ACR SITE DEVELOPMENT PLAN
GRADING AND EROSION CONTROL PLAN

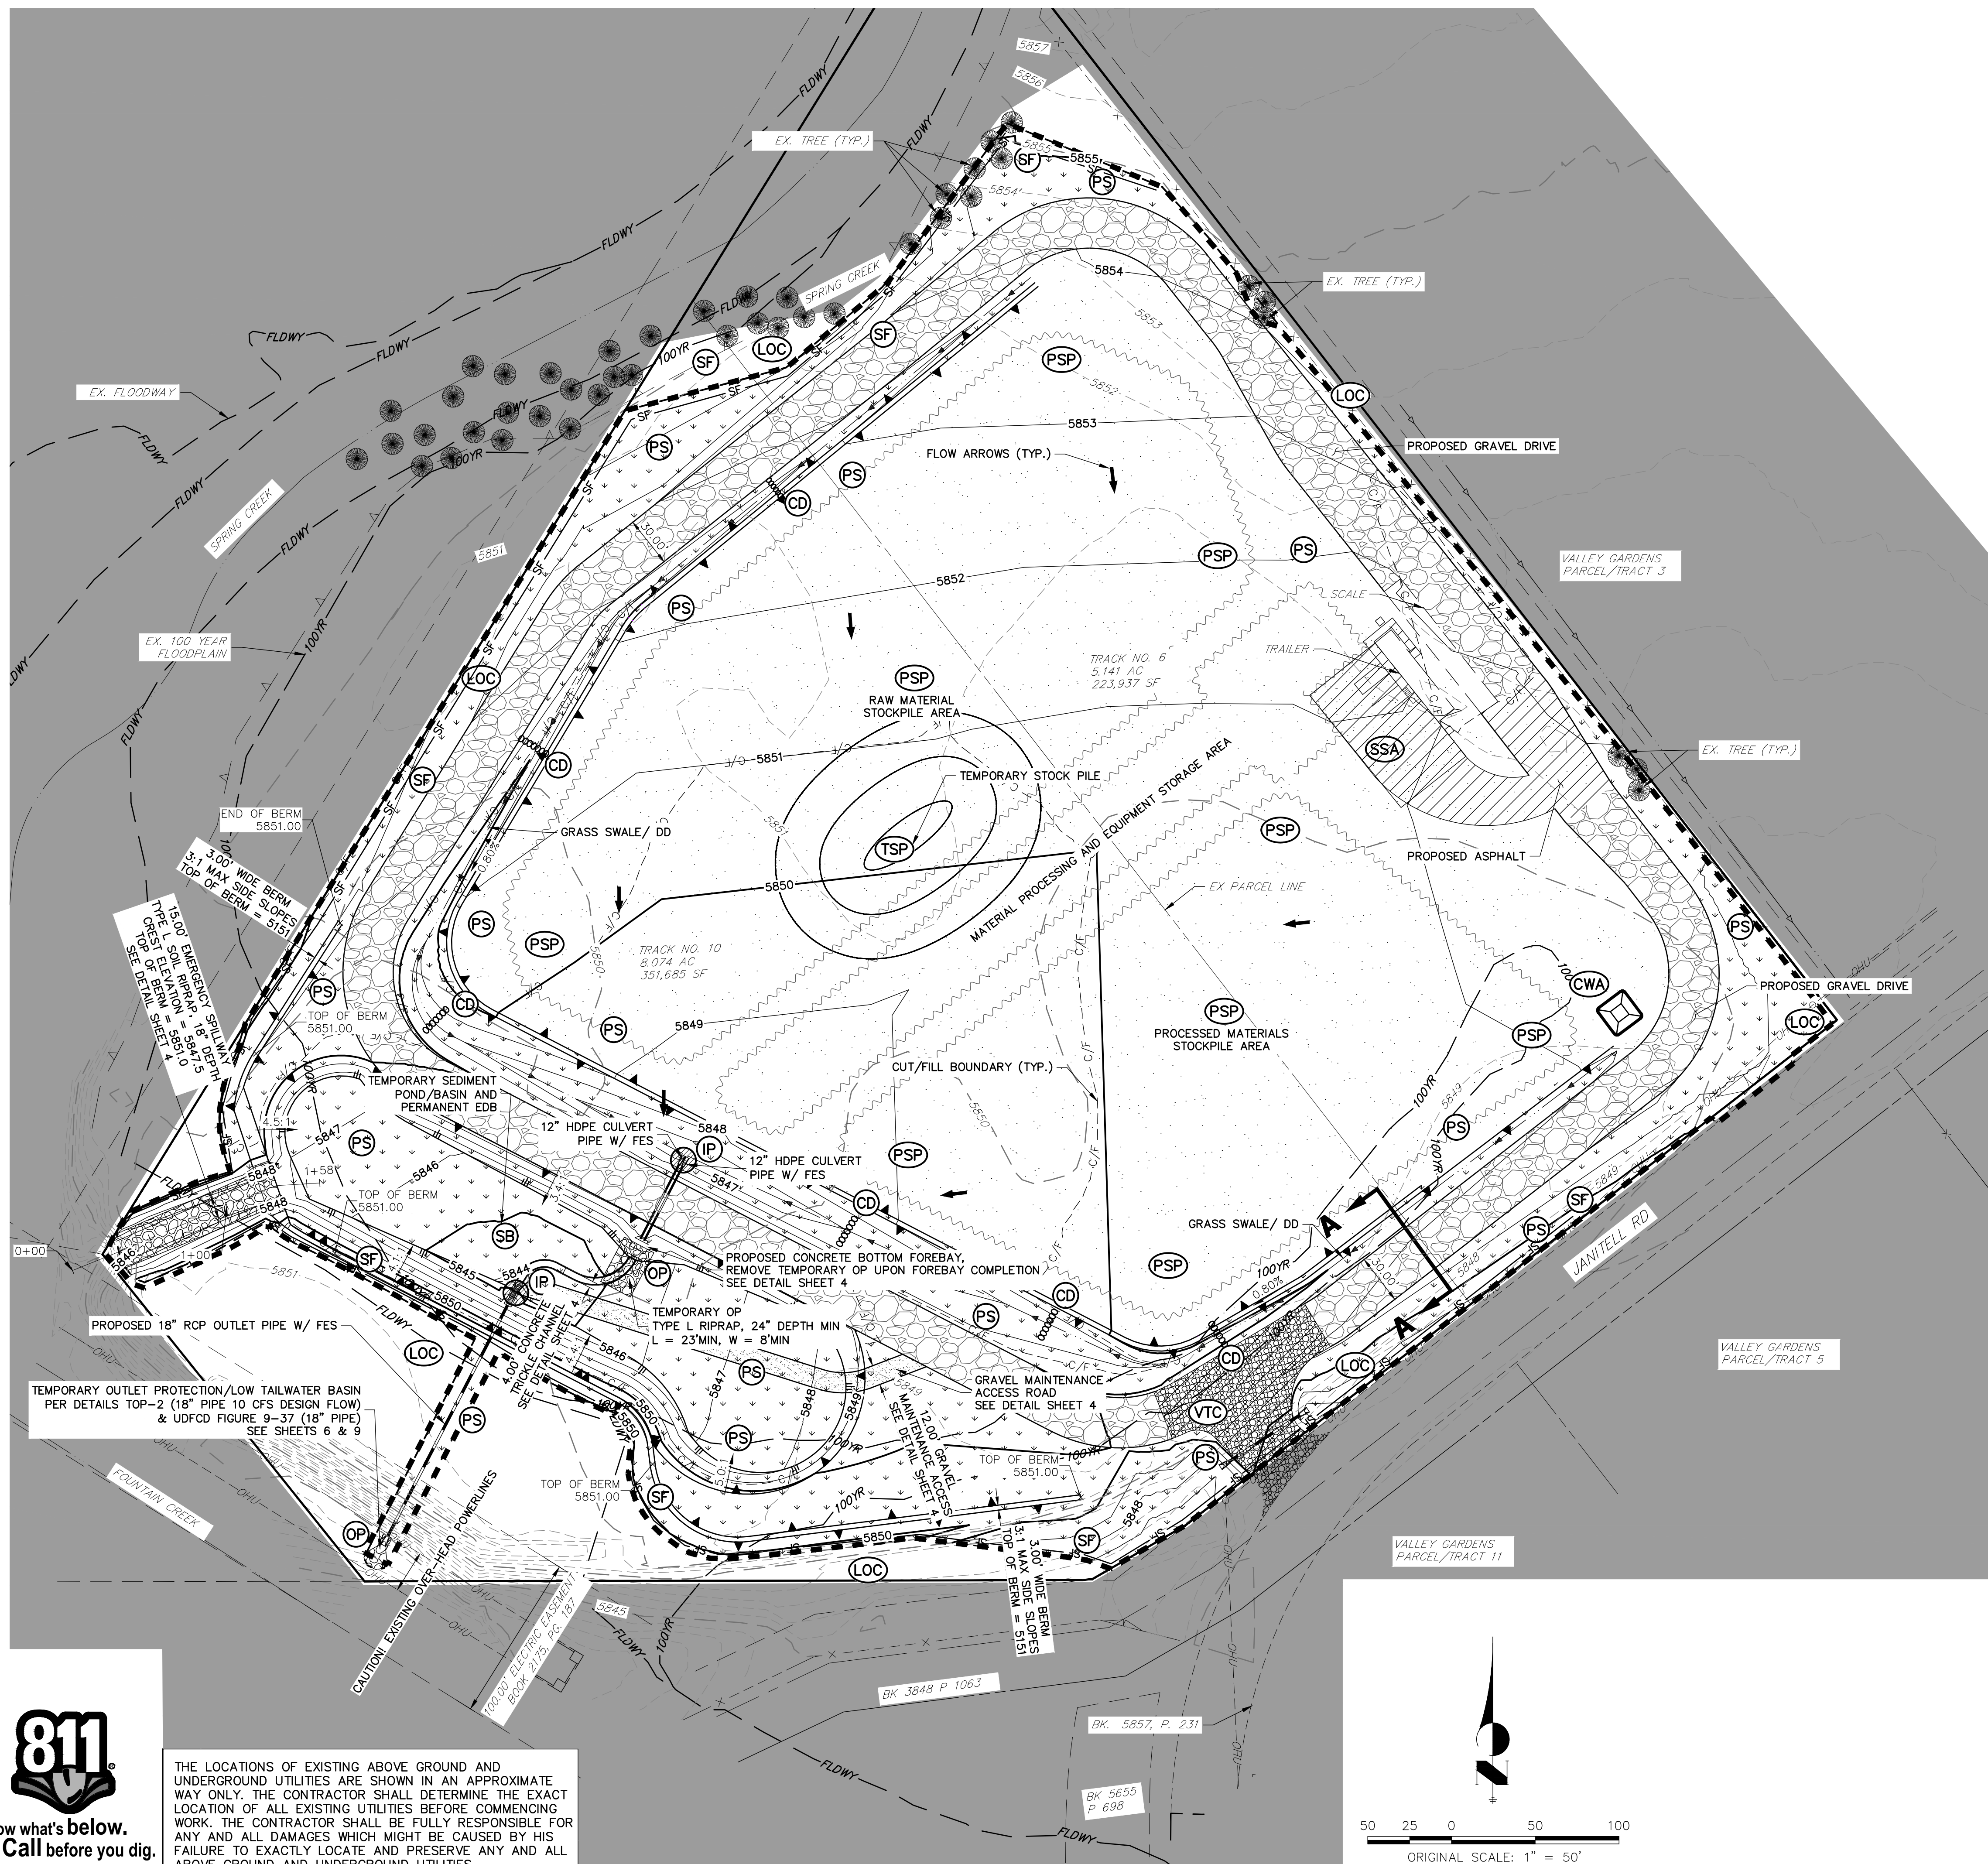
GEC shows spring
creek and fountain
creek

- h. location of all non-structural control measures;
- i. springs, streams, wetlands and other surface waters, including areas that require maintenance of pre-existing vegetation within 50 feet of a receiving water. **THERE ARE NOT WETLANDS OR STREAMS NEARBY THE SITE.**
